PROJECT NO. PR-2020-003658

Application No. SI-2020-01052 (EPC: SI-2020-00356)

Memorandum

Re: Overture at Andalucia DRB Comment Responses (PR-2020-003658)

**CP-502**

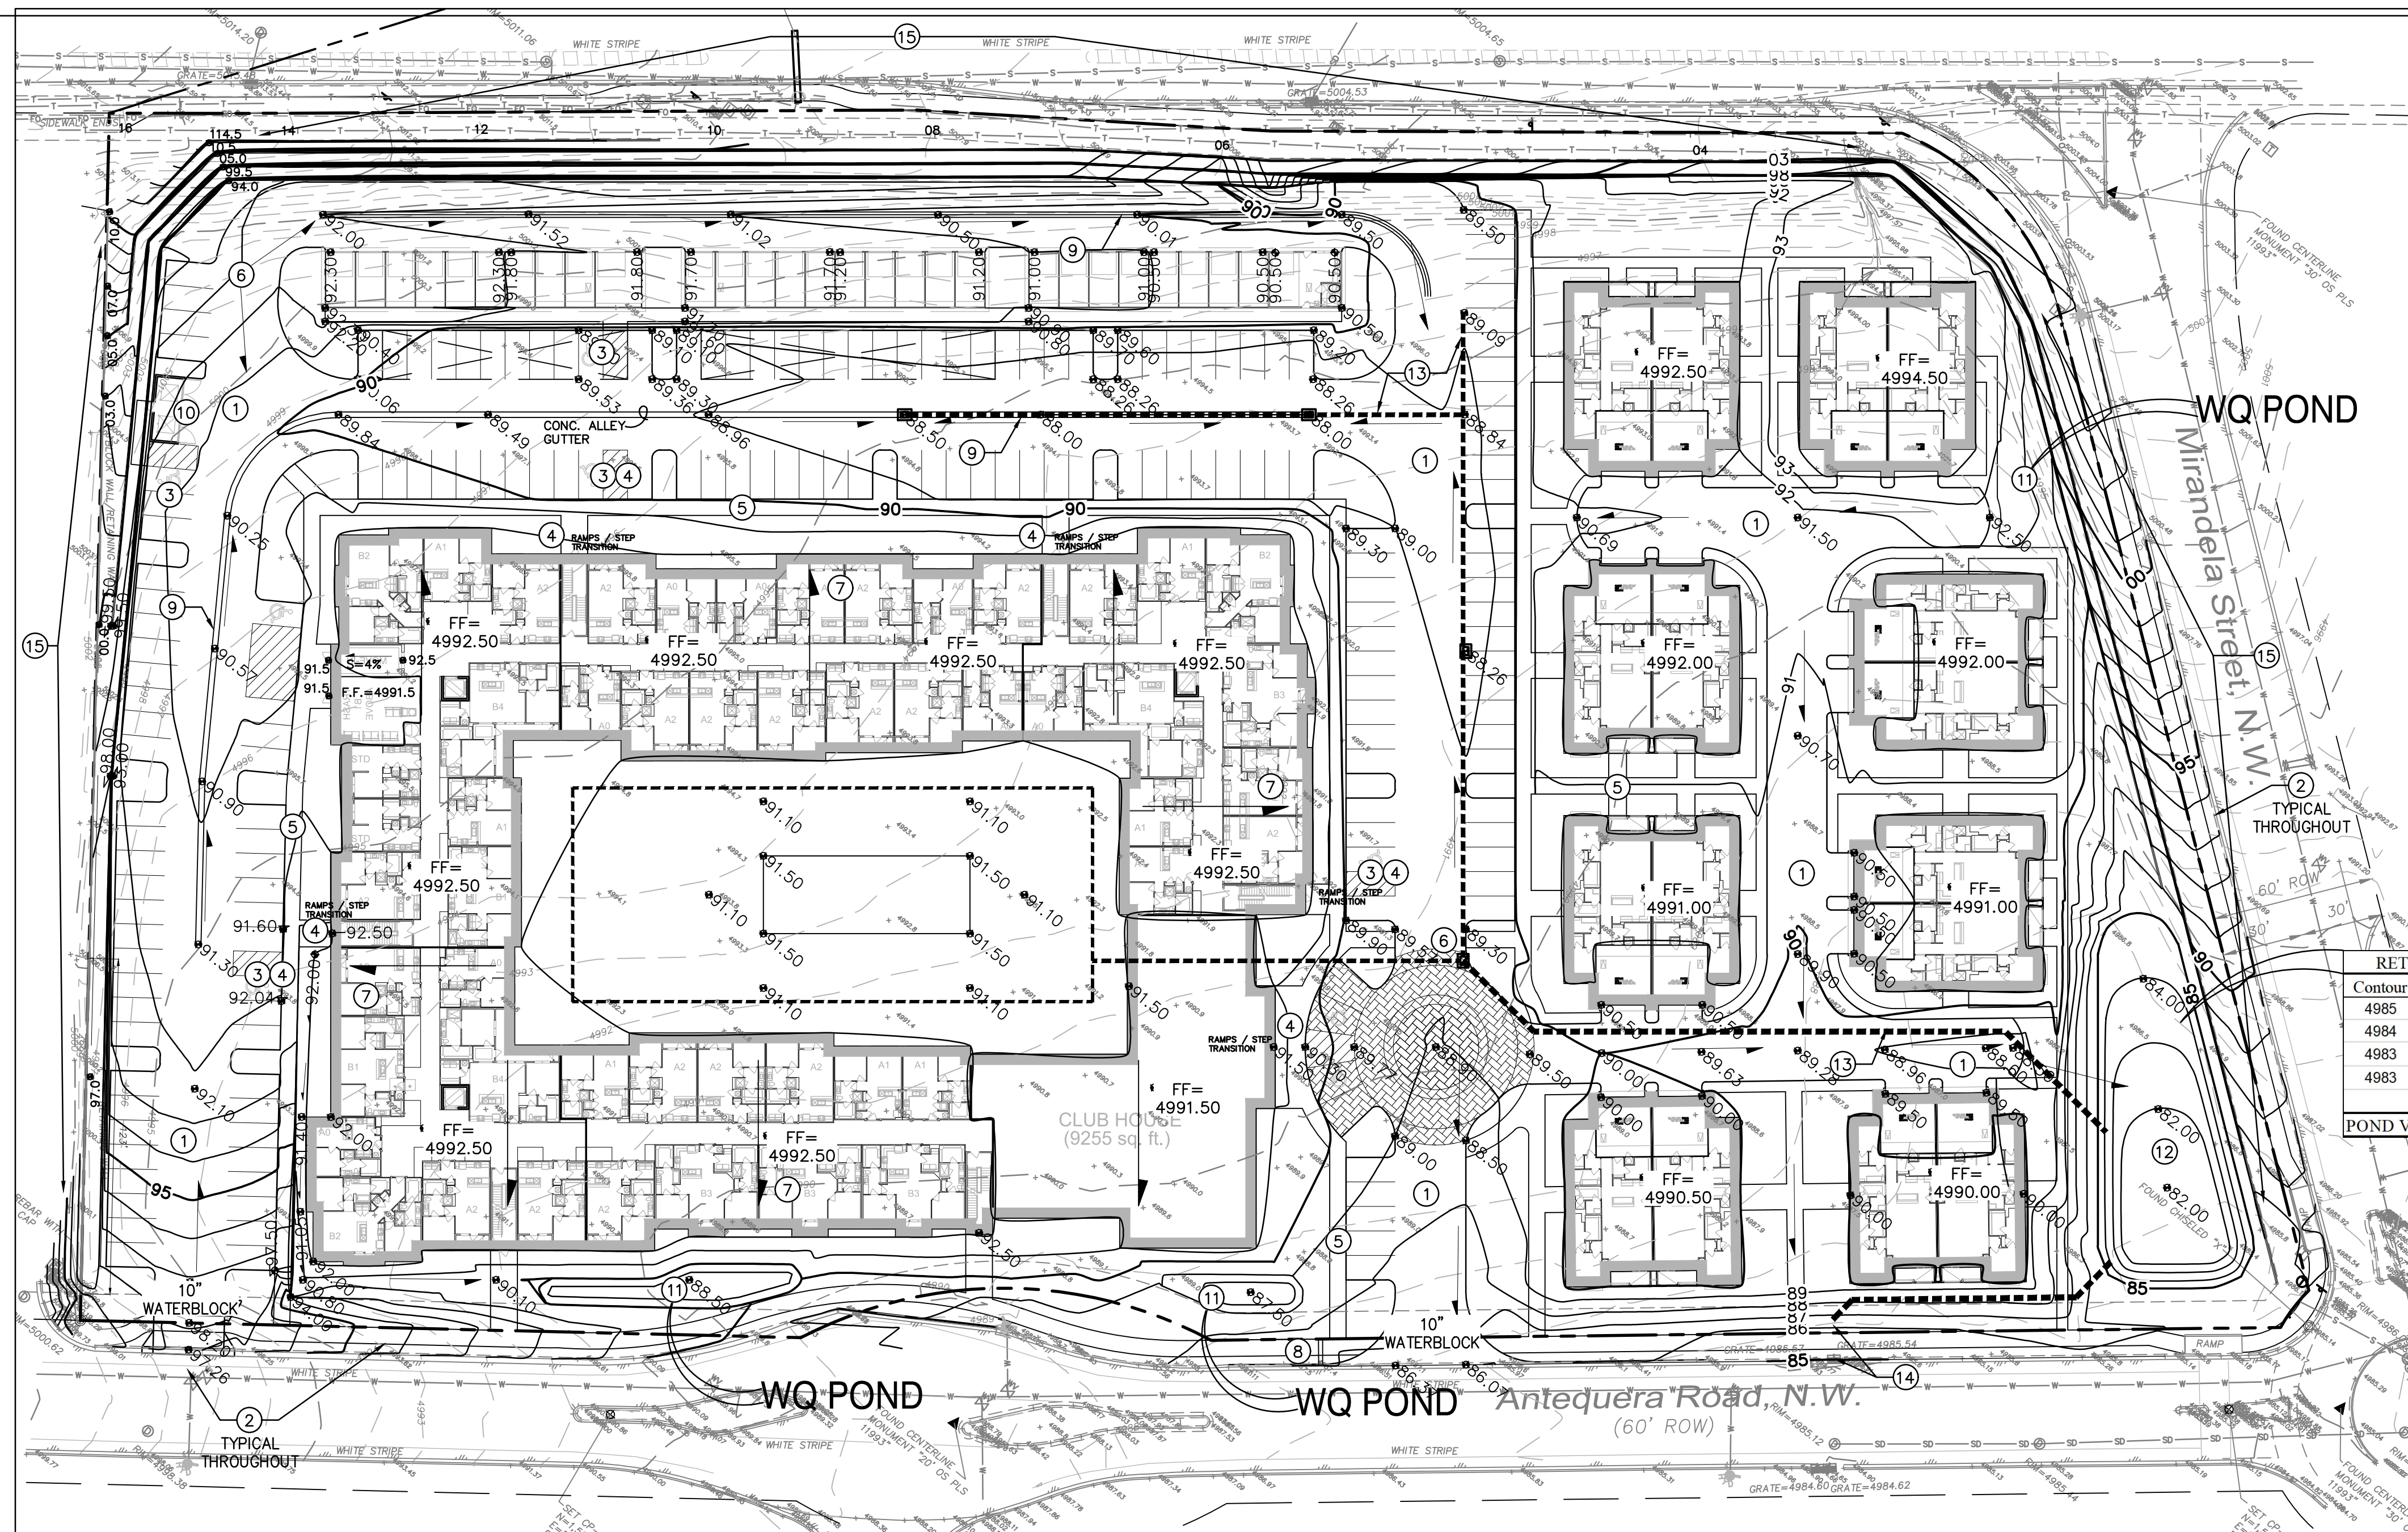
4. Identify all curb ramps what intersections, accessways, and any internal curb ramps are needed.
 - a. *New Keynote #24 identifies curb ramps throughout the site.*

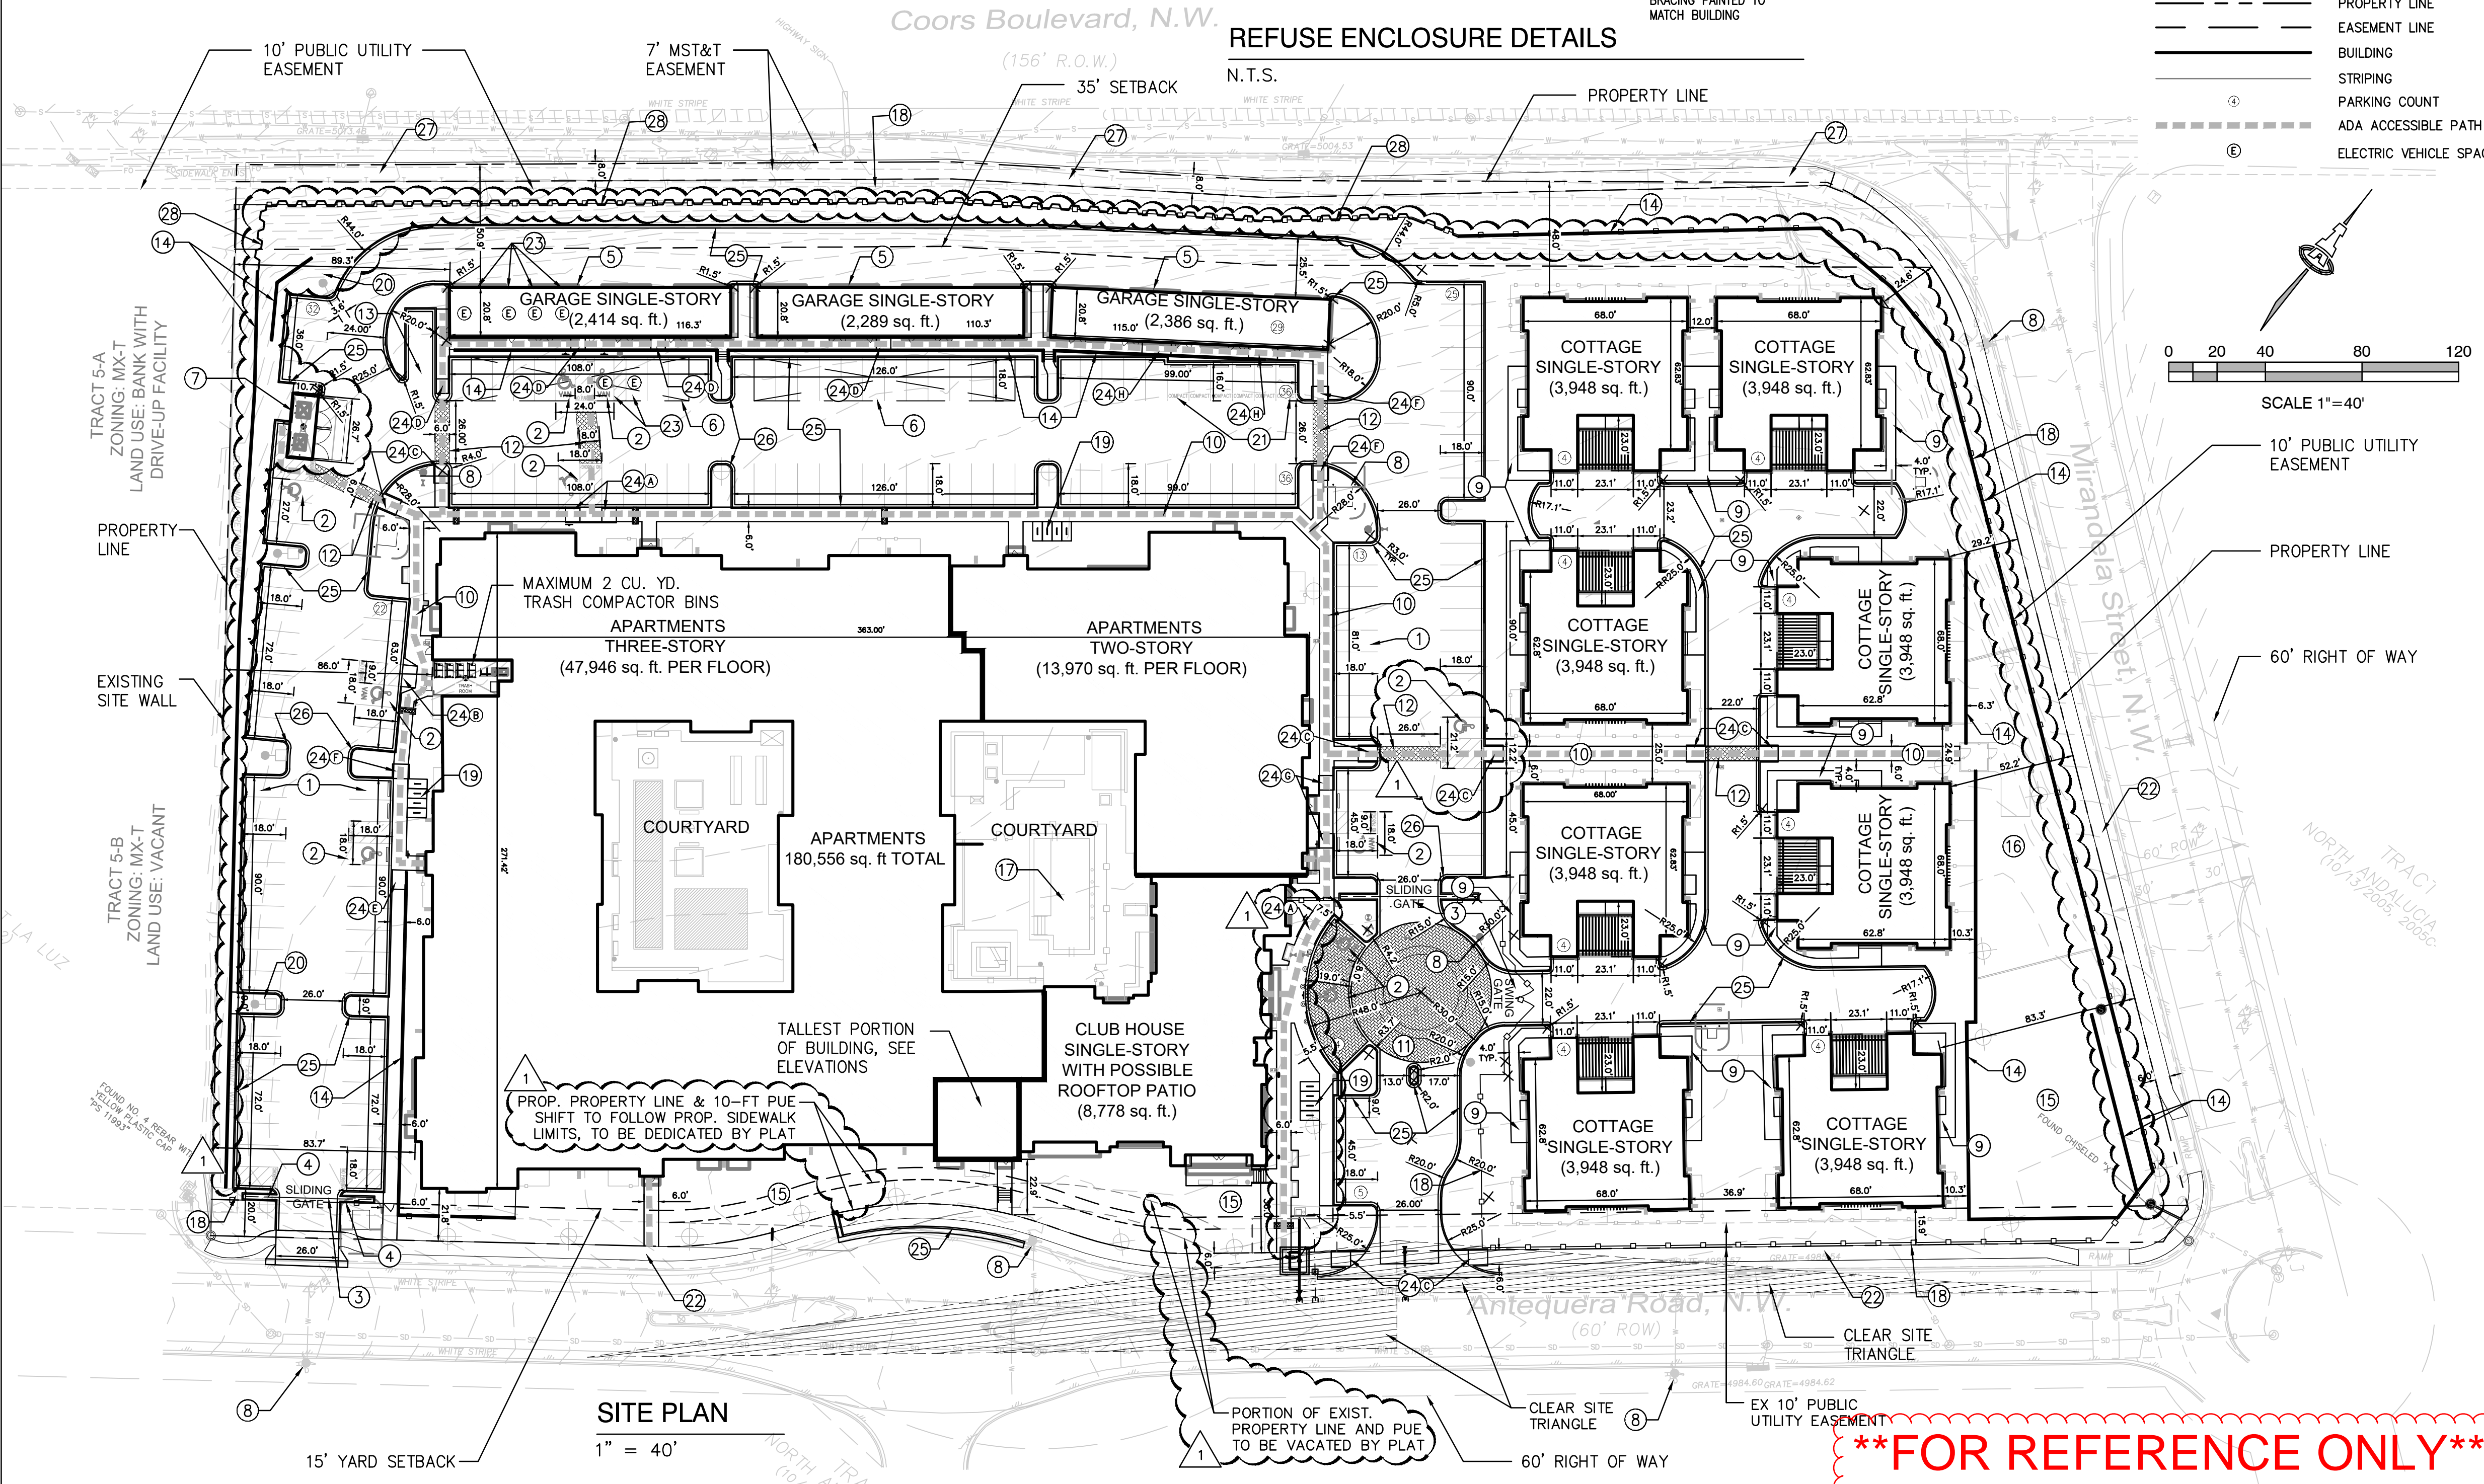
5. Curb that is 6" to 8" high should be shown to separate parking and aisles from landscaping and sidewalk.
 - a. *Keynote #25 identifies typical curb and gutter, which is detailed on Sheet CP-501.*

6. Show and label all curb radii.

- a. *Added to the plan and detailed on Sheet CP-501.*
- 9. The ADA access aisle shall have the words "**NO PARKING**" in capital letters, each of which shall be at least one foot high and at least two inches wide, placed at the rear of the parking space so as to be close to where an adjacent vehicle's rear tire would be placed. (66-1-4.1.B NMSA 1978)

- 12. Call out all handicapped spaces. One on the north side was not called out.
 - a. *Parking locations have been updated and called out.*

- a. *Keynote #26 identifies typical curb radii at parking and dimensions have been provided on the plan in other locations.*
- 7. Include TIS form sheet within the submittal as part of DRB package.

- a. *Added to the plan and detailed on Sheet CP-501.*
- 10. The ADA accessible parking sign must have the required language per 66-7-352.4C NMSA 1978 "**Violators Are Subject to a Fine and/or Towing.**" If that language is present it is not visible in the detail.
